From: Nicola Moore
Sent: 19 April 2022 10:40
To: Chris Moore
Cc: David Poole [REDACTED]
Subject: RE: Request for further information BR/77/22/PL - 42 Sudley Road, Bognor Regis.

From: Chris Moore [REDACTED]
Sent: 08 April 2022 16:58
To: Nicola Moore [REDACTED]
Cc: David Poole [REDACTED]
Subject: Request for further information BR/77/22/PL - 42 Sudley Road, Bognor Regis.

PROPOSED ROOF PLAN

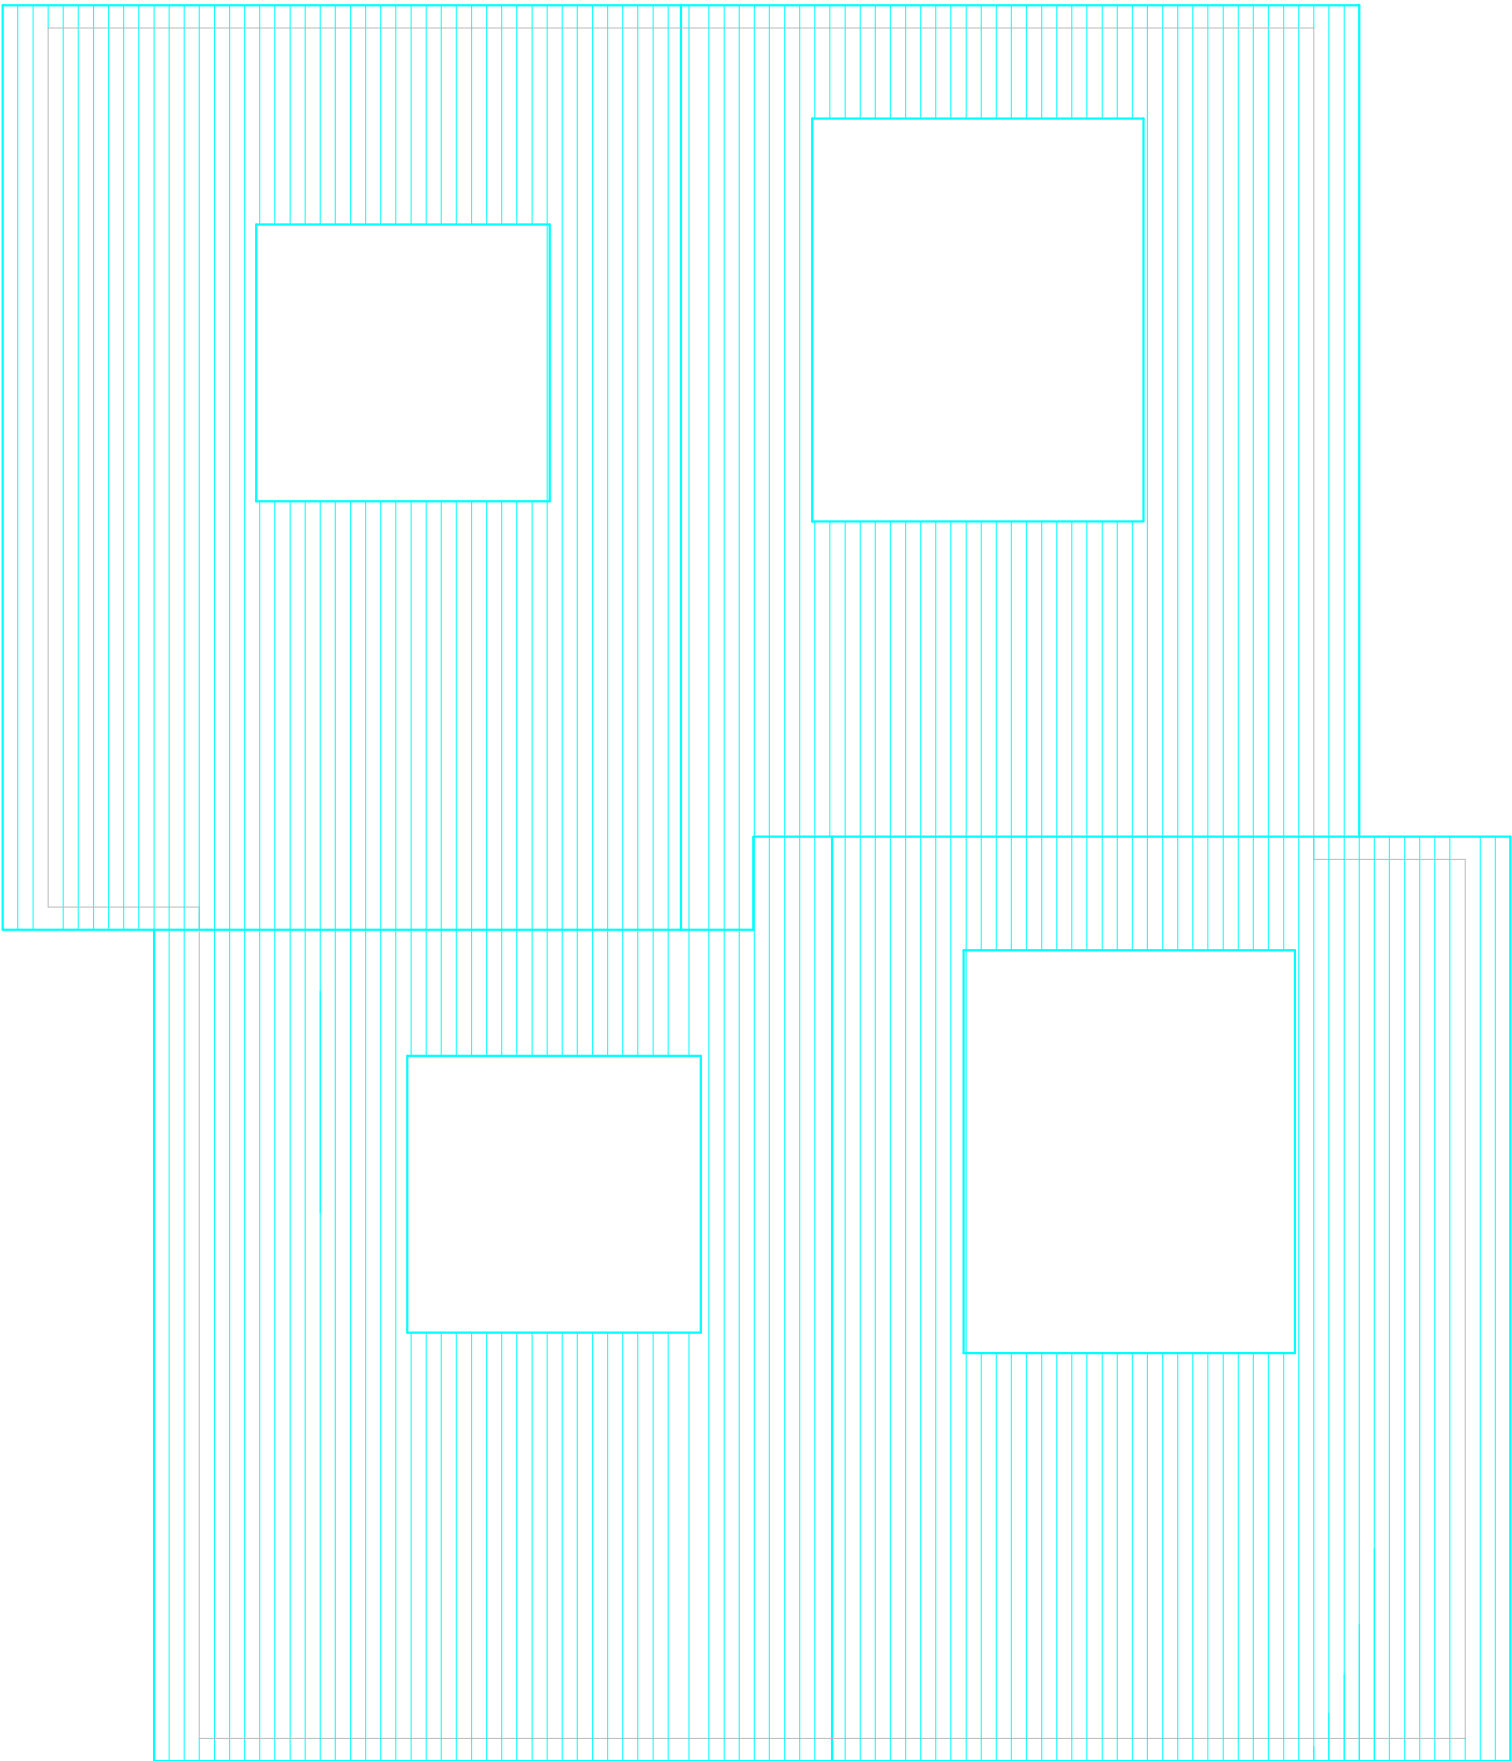
I cannot see the proposed roof plan as requested on 8th April, please forward accordingly.

LOCATION PLAN - 1/1250

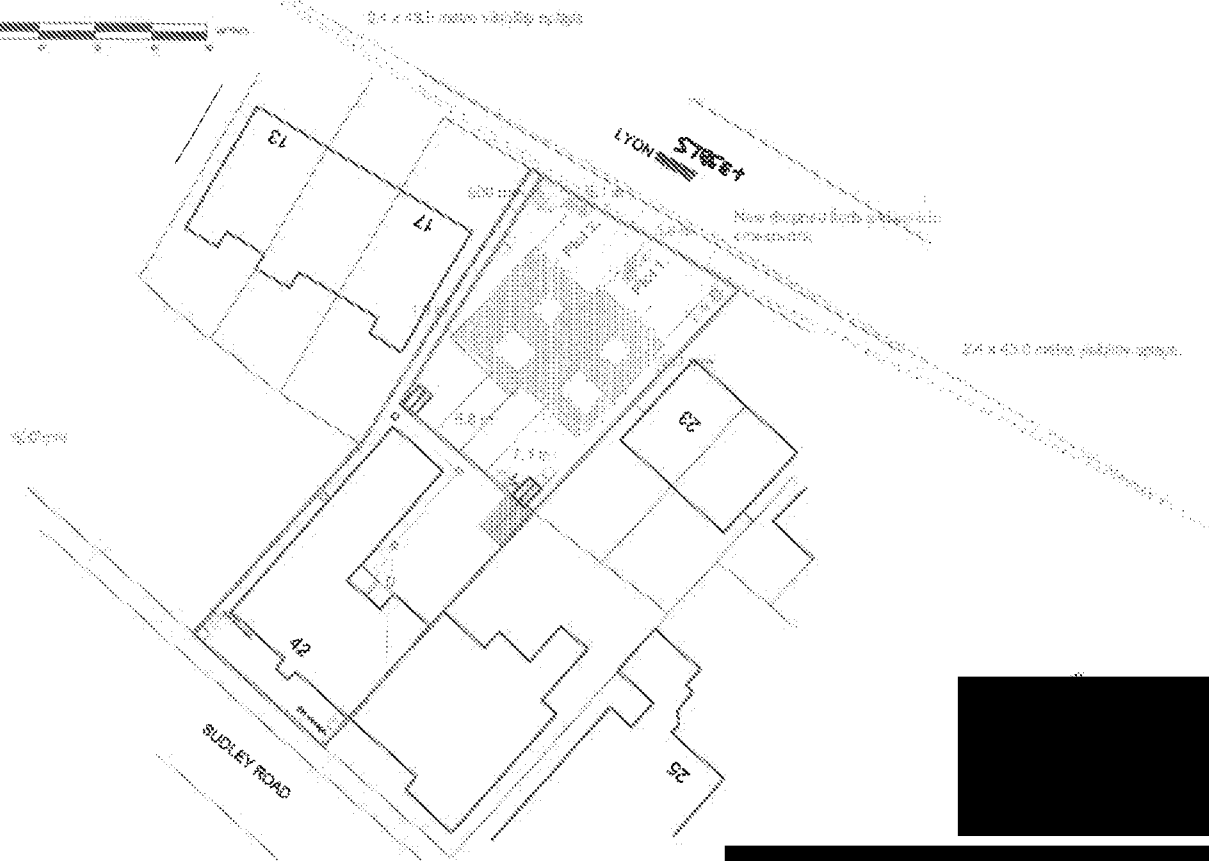
1. Location Plan – showing visibility splays. The red edge as drawn covers the land owned by the applicant which is part of this site. The public pathway is not under their ownership (WSCC Highways) are you sure this should be red edged? I have checked this with Nicola Spencer, the red edge should include the new access and notice served on relevant parties.
2. Amended elevations are attached showing the correct window size. These are now okay,
3. Site section attached. Uploaded and okay.
4. Visibility splays are shown on the site/location plan. Uploaded and okay.
5. Pagham Harbour Management Contribution Legal Agreement and Fee – I will get the applicants to organise a signed unilateral undertaking together with the appropriate legal checking fee. I will await receipt of the signed agreement and legal checking fee.

1. Location Plan – showing visibility splays. The red edge as drawn covers the land owned by the applicant which is part of this site. The public pathway is not under their ownership (WSCC Highways) are you sure this should be red edged?
2. Amended elevations are attached showing the correct window size.
3. Site section attached.
4. Visibility splays are shown on the site/location plan.
5. Pagham Harbour Management Contribution Legal Agreement and Fee – I will get the applicants to organise a signed unilateral undertaking together with the appropriate legal checking fee.
